**Town & Country Planning (Control of Advertisement) (England) Regulations 2007 (as amended)**

Application No: CM/3/22/A  
Site Address: Maidenhead Aquatics Crookthorn Lane Climping BN17 5SN  
Description of works: Installation of 1 x internally illuminated fascia sign.

Thank you for your internet representation made on 19th February 2022 which has been recorded as an objection with the comments as follows:

DRAWING TITLE
As-Existing Elevations with Sign 1 Details

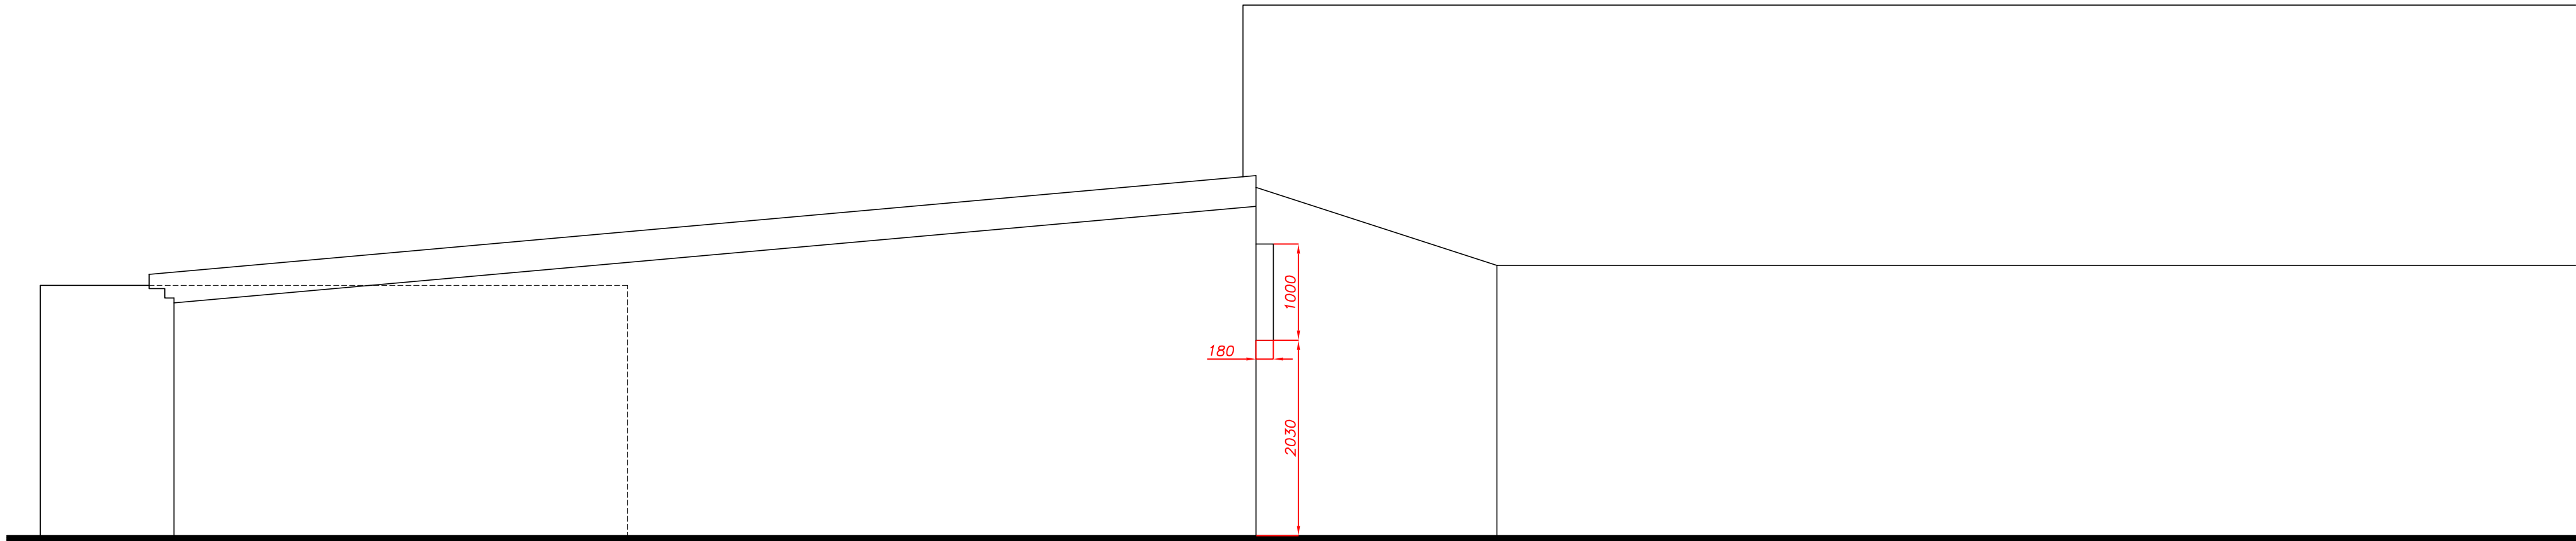
An illuminated plastic signage box is out of keeping with a farm shop in a rural area.  
The proposed illumination of 634cd/m<sup>2</sup> is higher than the recommended illumination advice by WSCC and by Arun District Council.
